DEPARTMENT OF PARKS AND COMMUNITY SERVICES

May 30, 2024

Subject: Thompson Thrift Apartments Rezone Review (P-24-007)

REZONE MAP EXHIBIT

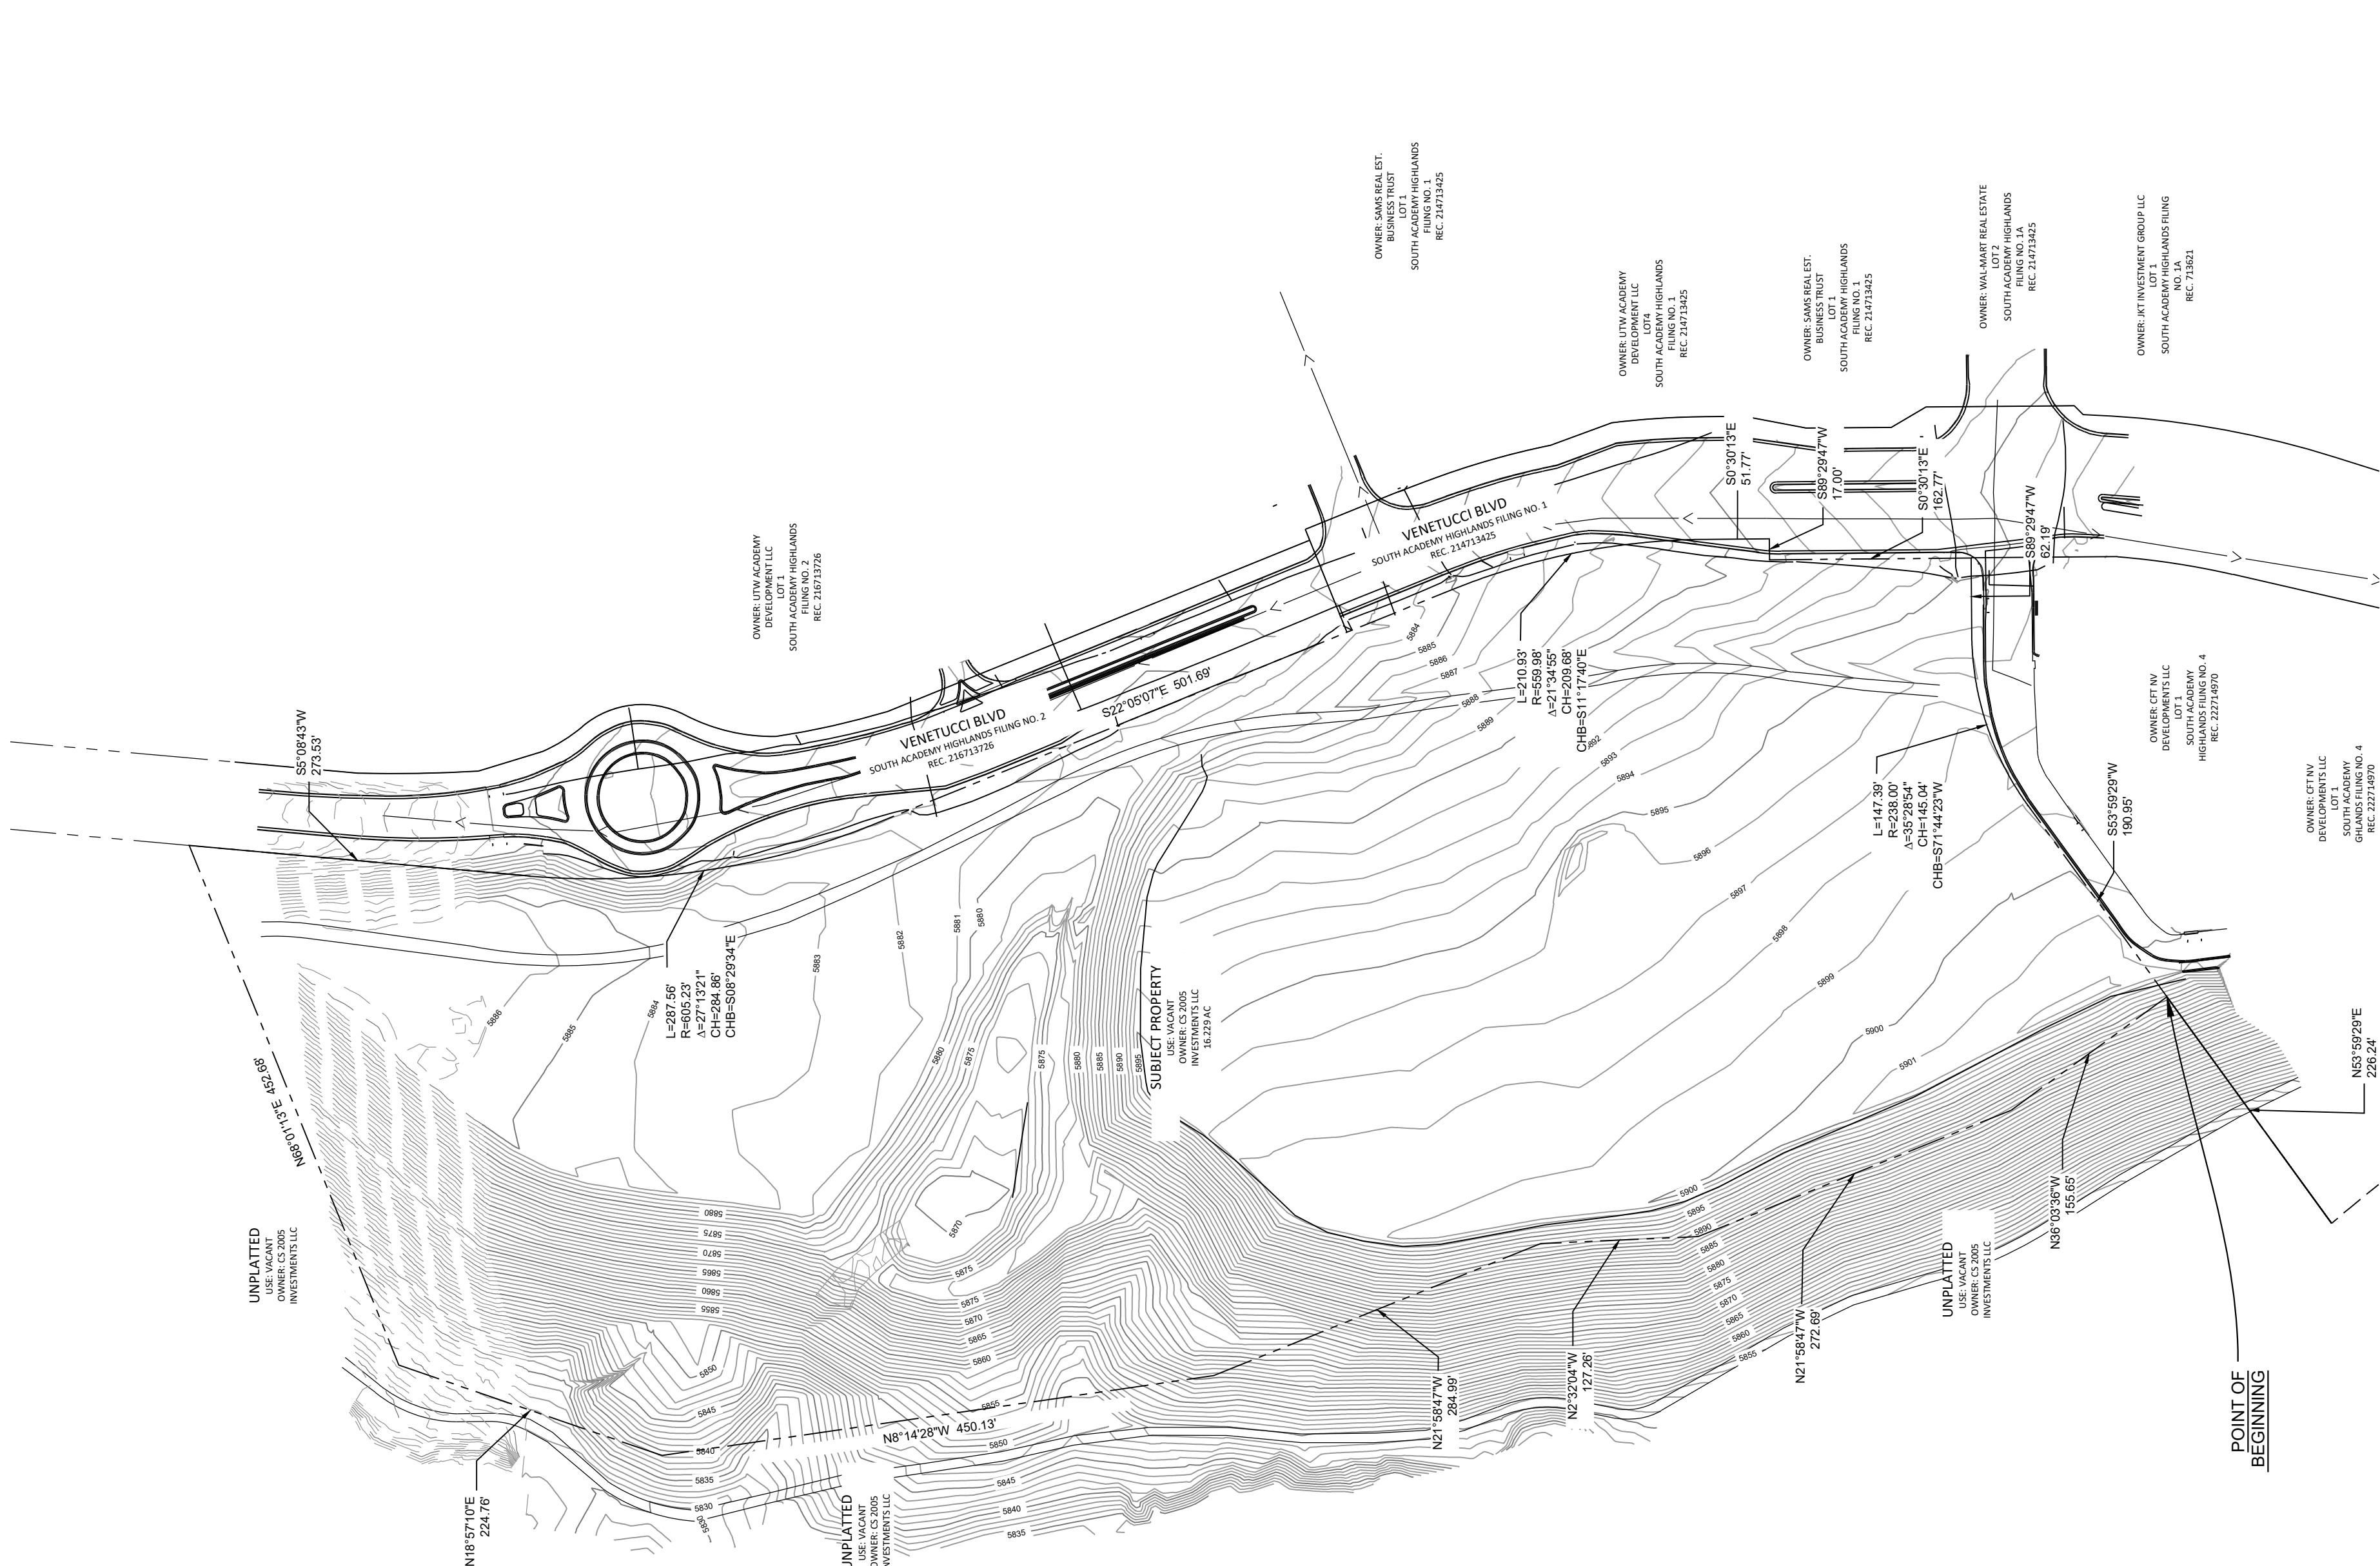
However, if the parent parcel remains unchanged, then El Paso County Parks and Community Services will request a 25-foot trail easement for the planning, construction, maintenance, and public access of the B-Street Secondary Regional Trail. The location of the trail, as shown on the South Academy Station PUD Plan in the applicant's Letter of Intent, is acceptable to EPC Parks staff, as it generally follows the original master planned alignment.

ACKNOWLEDGED, A SEPARATE PARCEL IS BEING CREATED FOR THE APARTMENT SITE.
